DRB Application No.: 07DRB-00601 (SBP)  
Project Name: TOWN OF ATRISCO GRANT UNIT 7  
Agent: Tierra West LLC

TO: Sheran Matson, DRB Chair  
FROM: Stephanie Shumsky, Planner  
SUBJECT: Project # 1005242

On December 21, 2006, the Environmental Planning Commission approved Project # 1005242/06EPC-01588, a request for a site development plan for building permit for all or a portion of Tract A-1-E, Unit 7, Town of Atrisco Grant, located on Sage Road SW between Snow Vista Blvd. SW and Reba Road SW, containing approximately 2-acres.

COMPASS BANK	DRAWN BY
	98TH AND SAGE	ET
	SITE PLAN FOR	DATE
	BUILDING PERMIT	05/07/07
5571 MIDWAY PARK PLACE NE ALBUQUERQUE, NM 87109 (505)858-3100		26049-SPB
		SHEET #
	C1	
	JOB #	26049

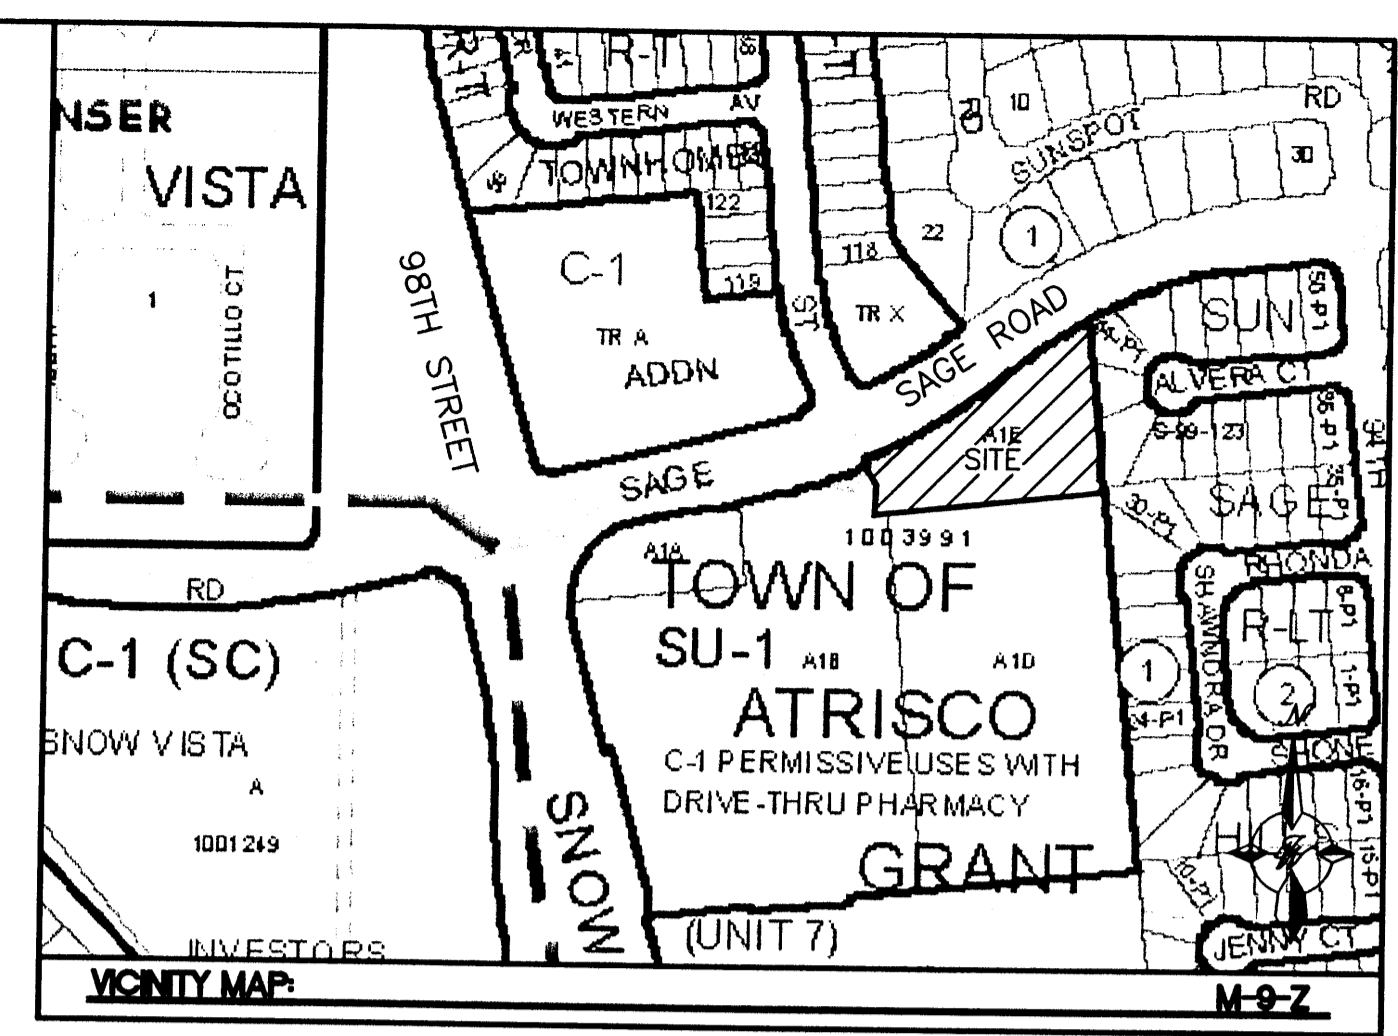
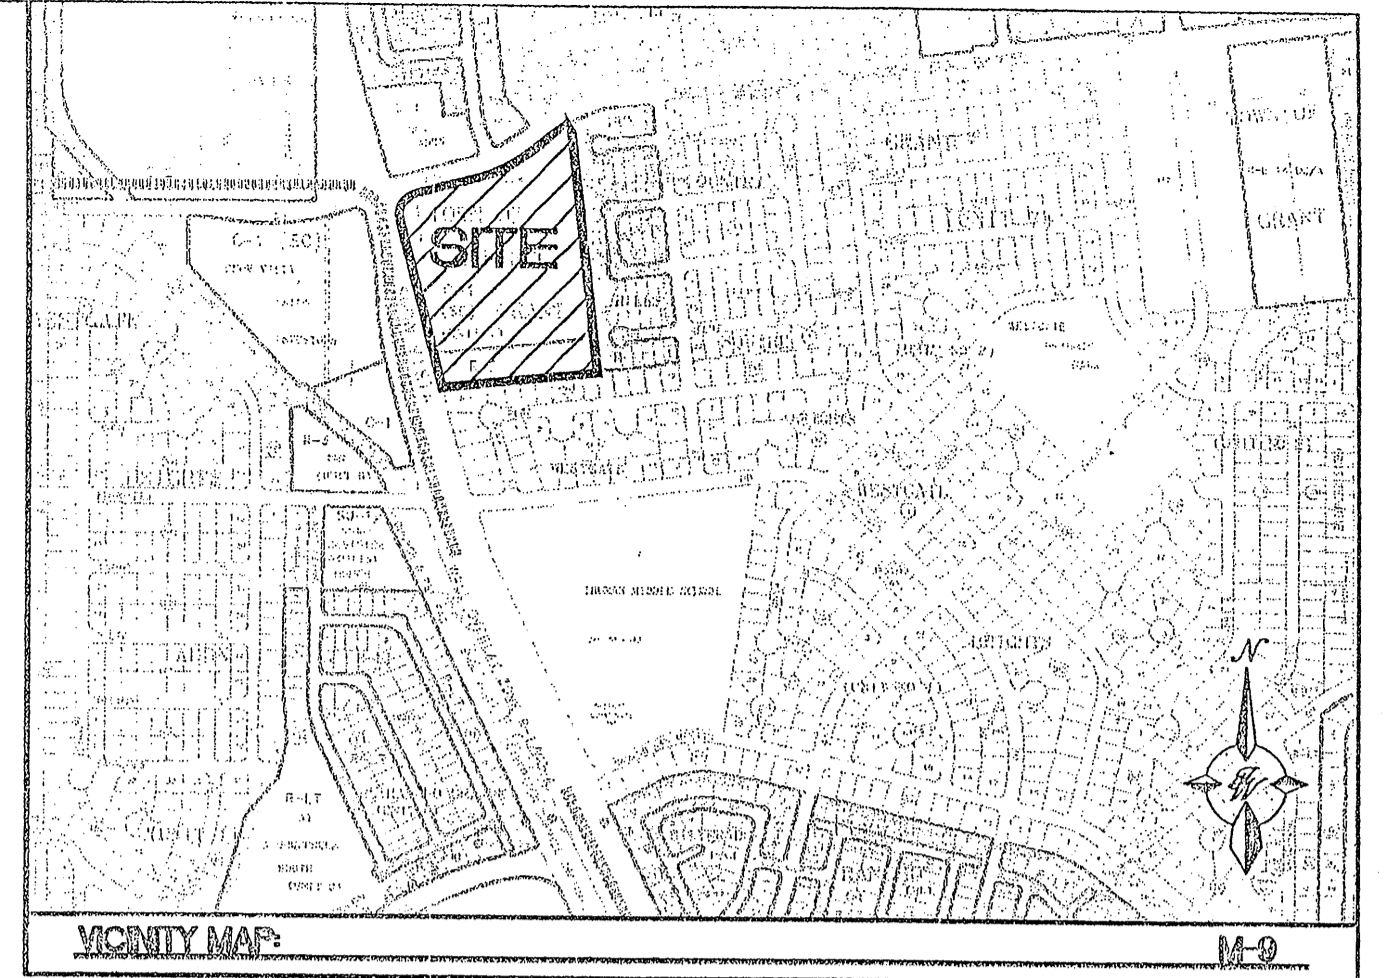
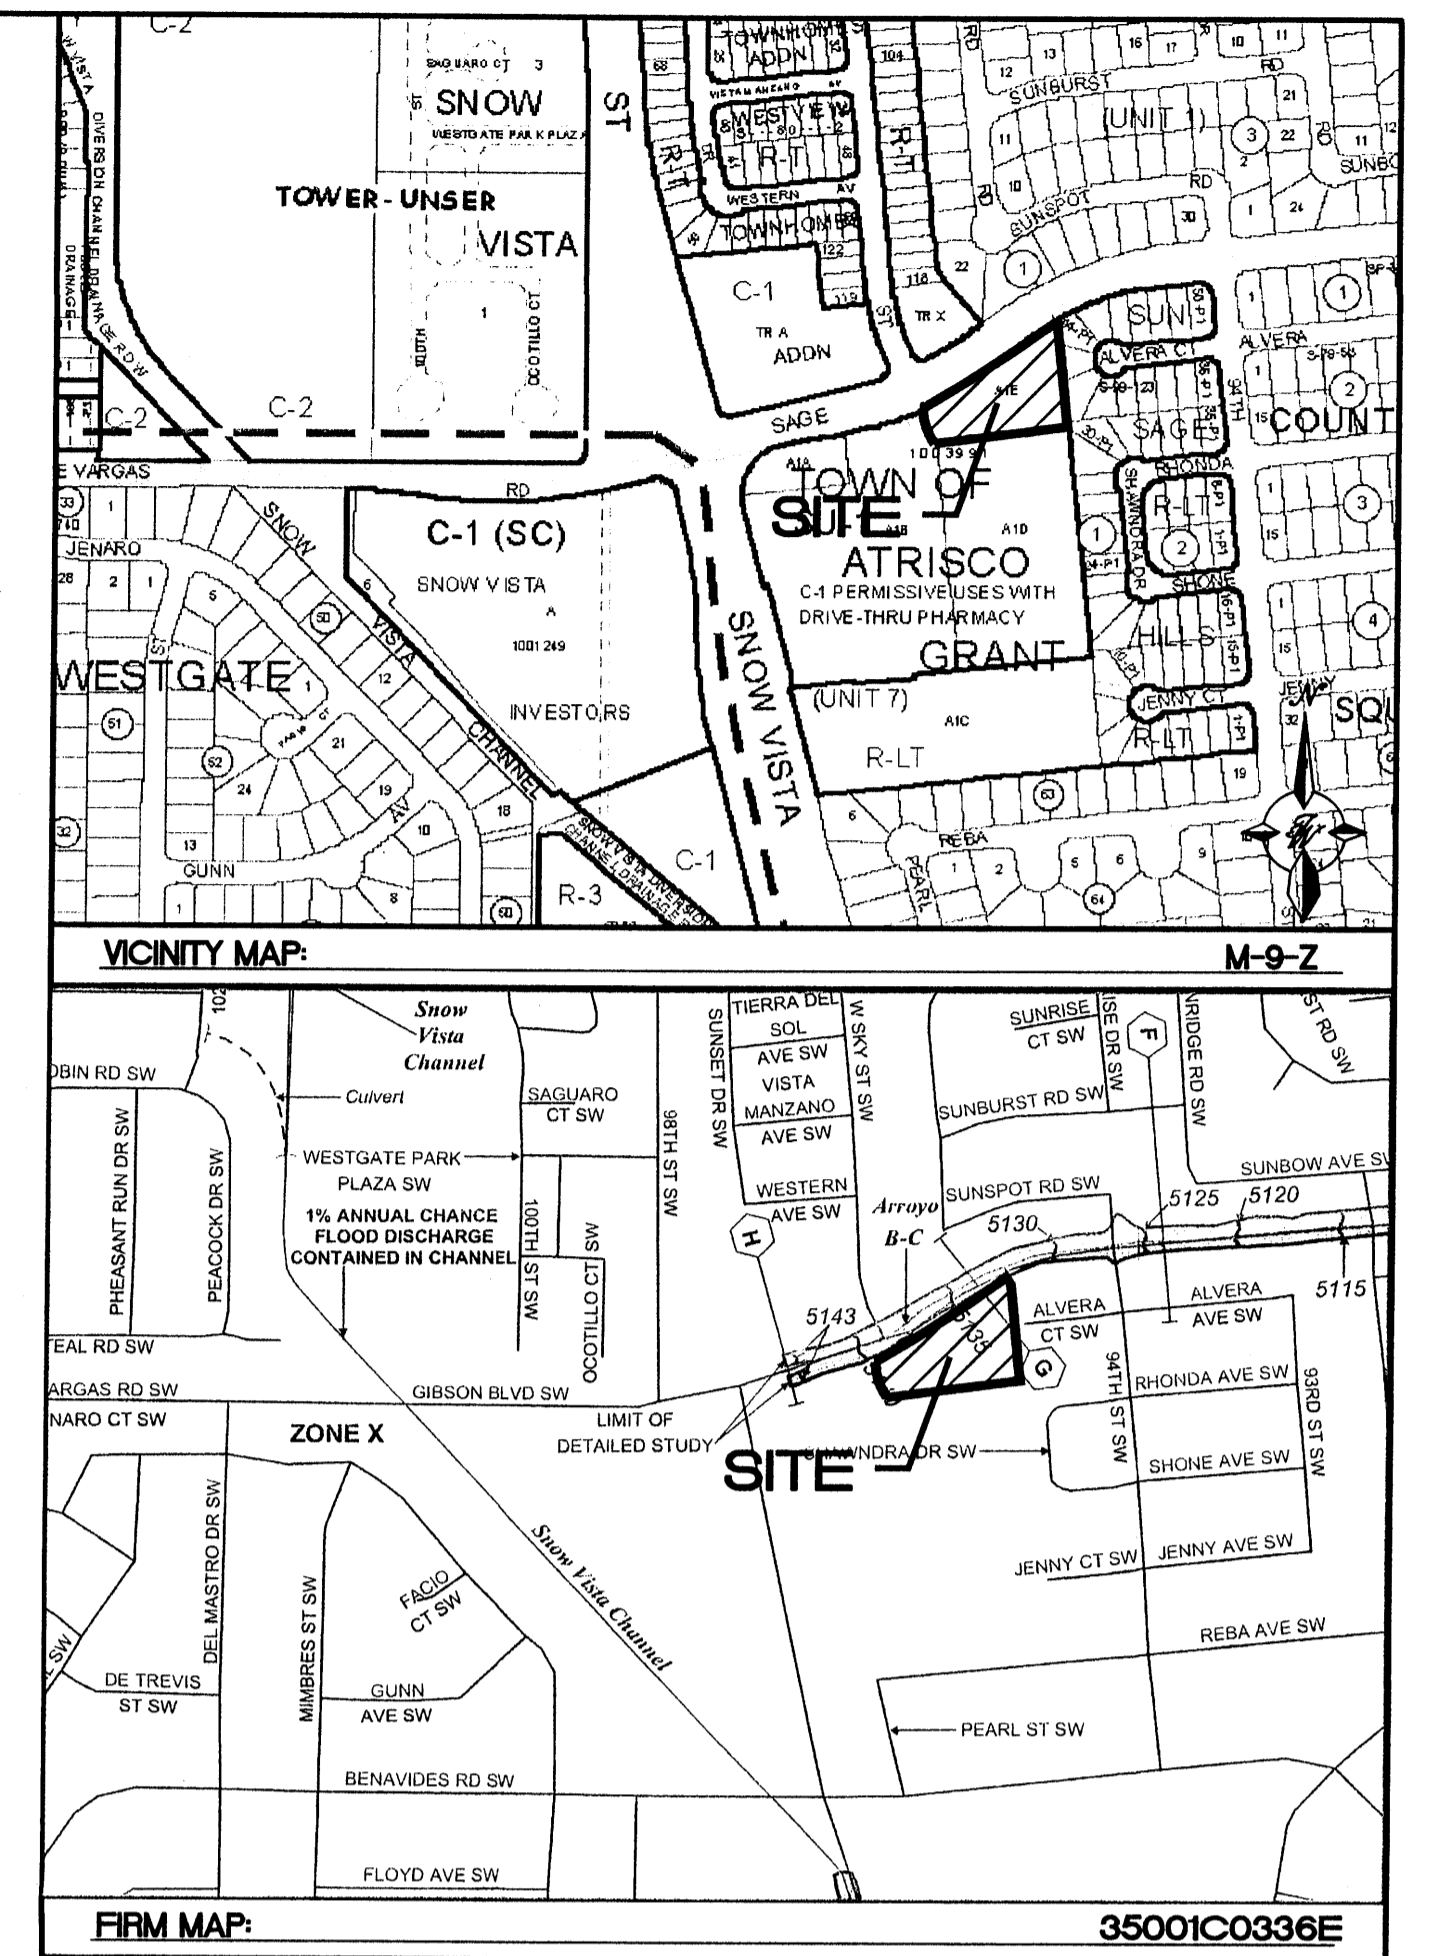
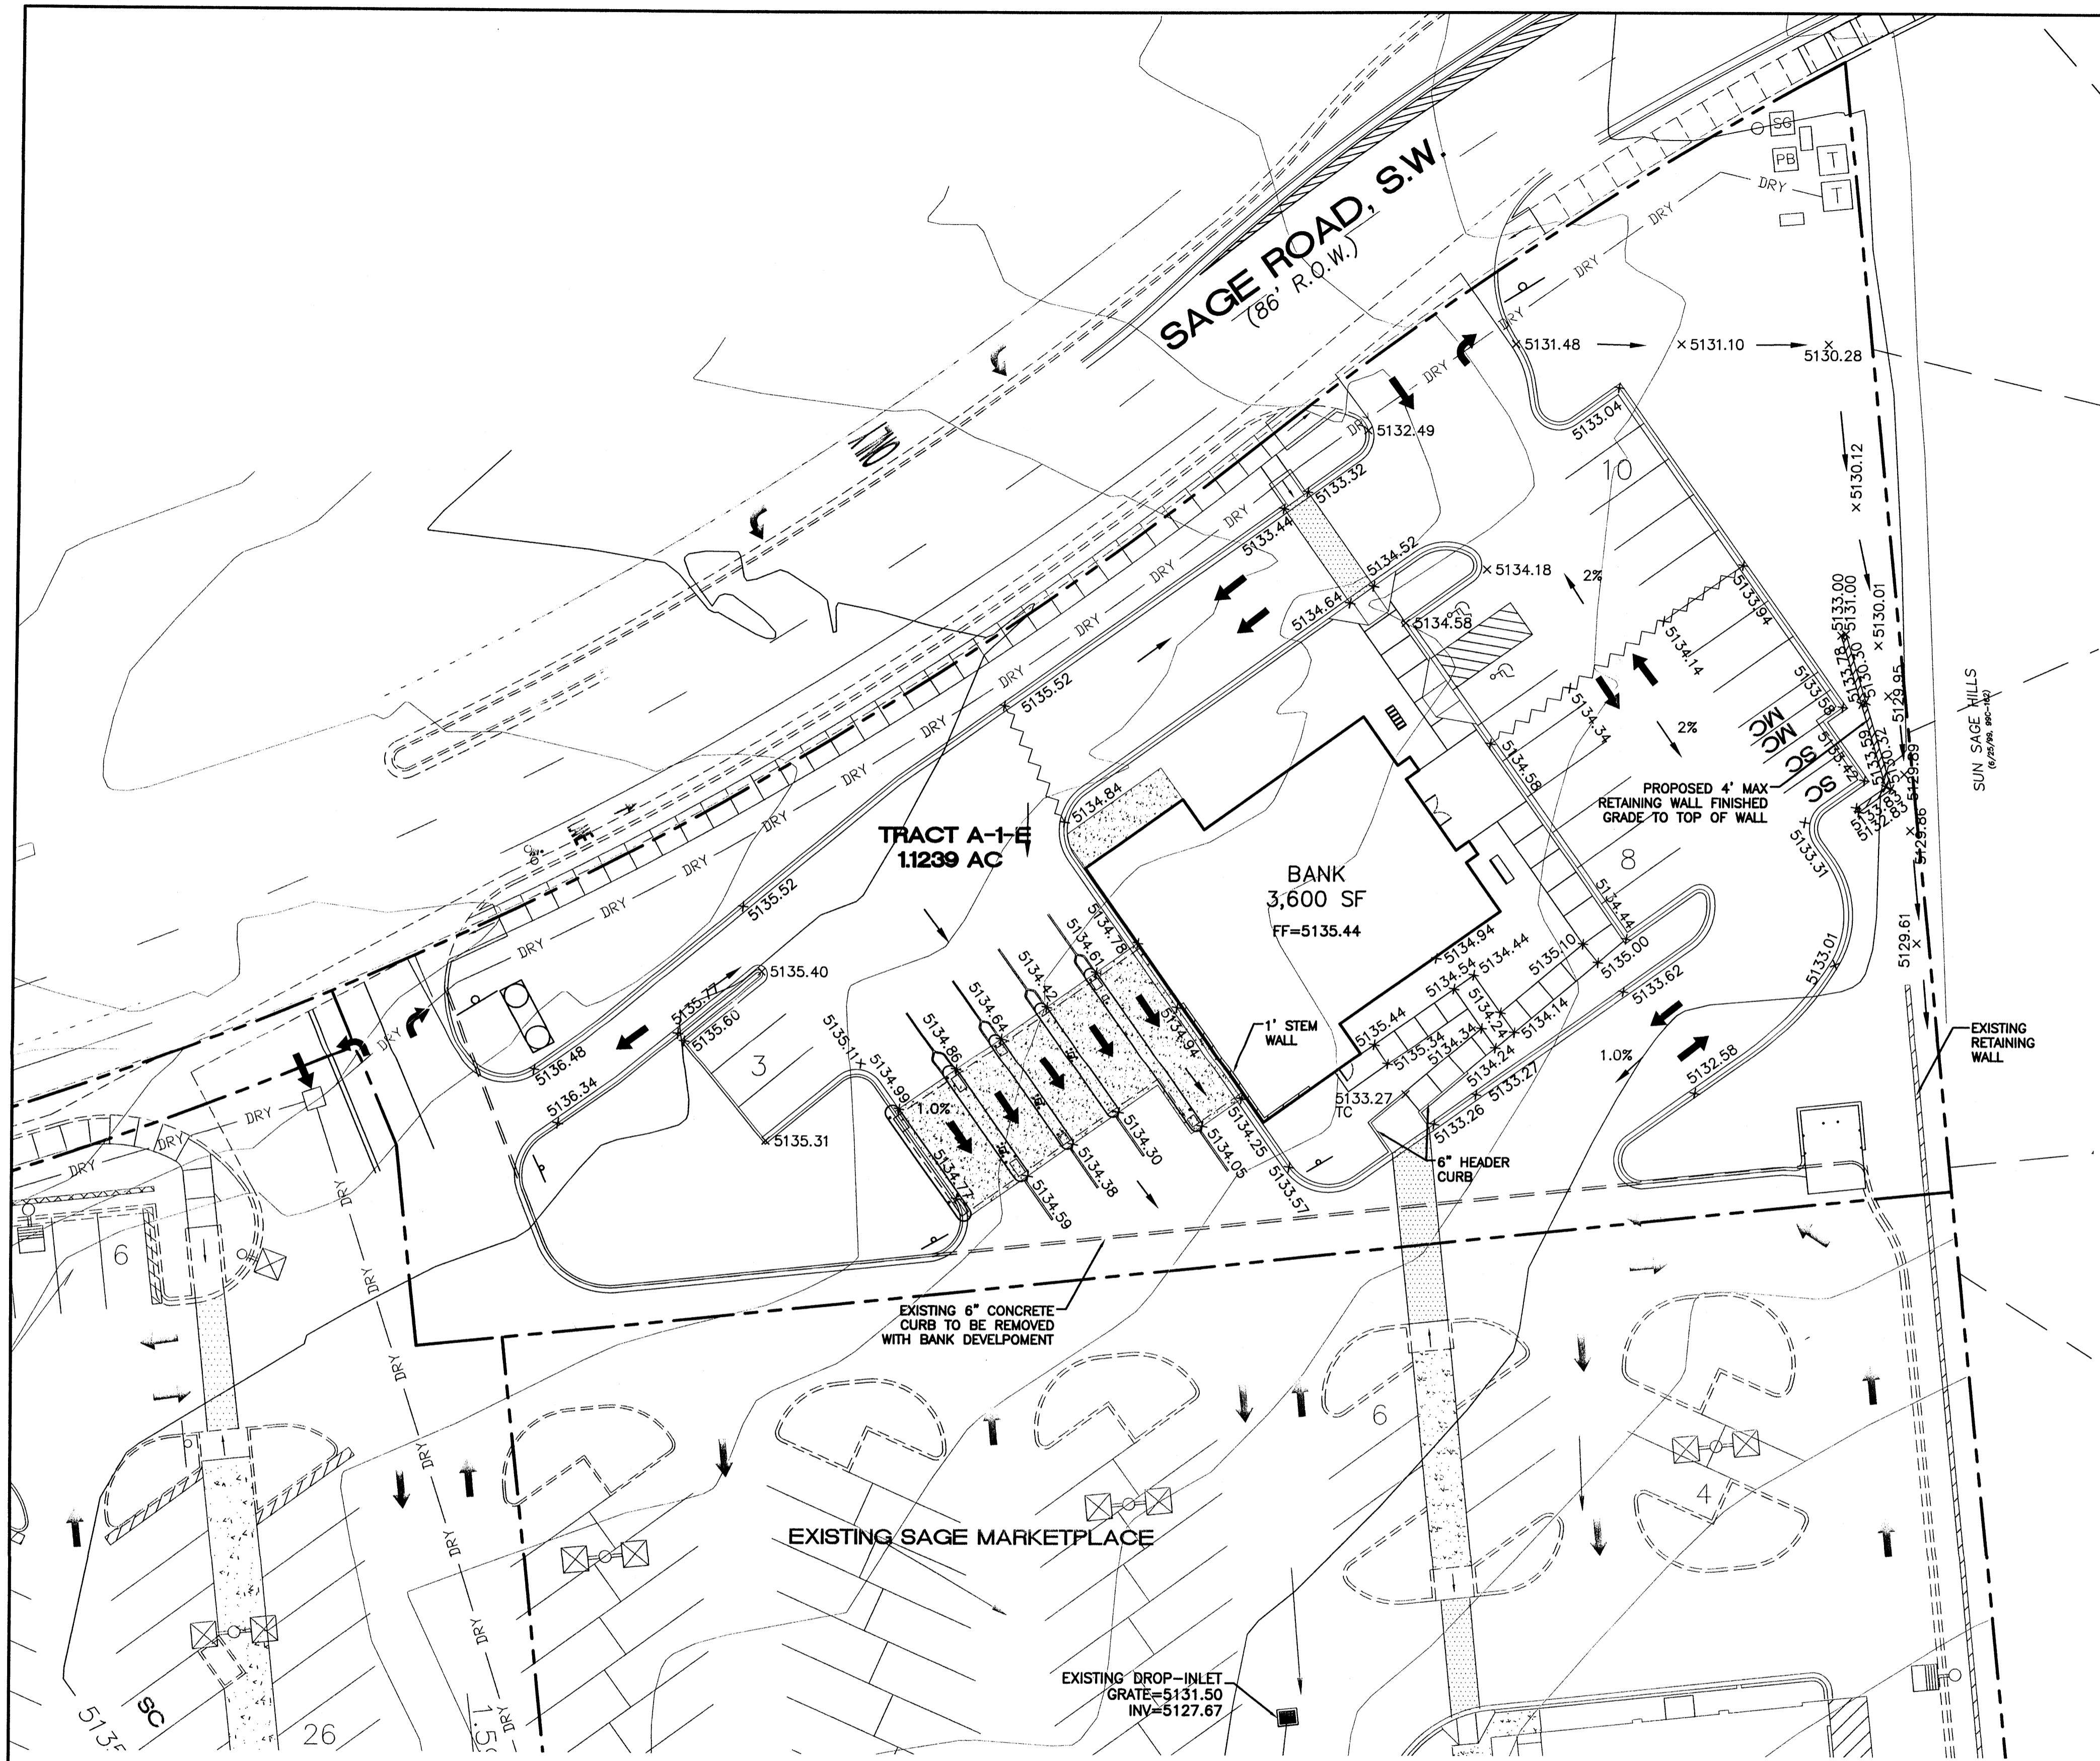
- The scale on sheet C1 is incorrect (it is not 1"=20').
- The proposed walls/retaining walls on the eastern edge of the site are not shown consistently on all sheets and are not what the EPC approved.
- Keyed note #15 is not identified on the site plan. The note is not consistent with what was approved/conditioned on the EPC submittal.
- Keyed note #16 is not identified on the site plan.
- Keyed note #17 is not identified on the site plan.
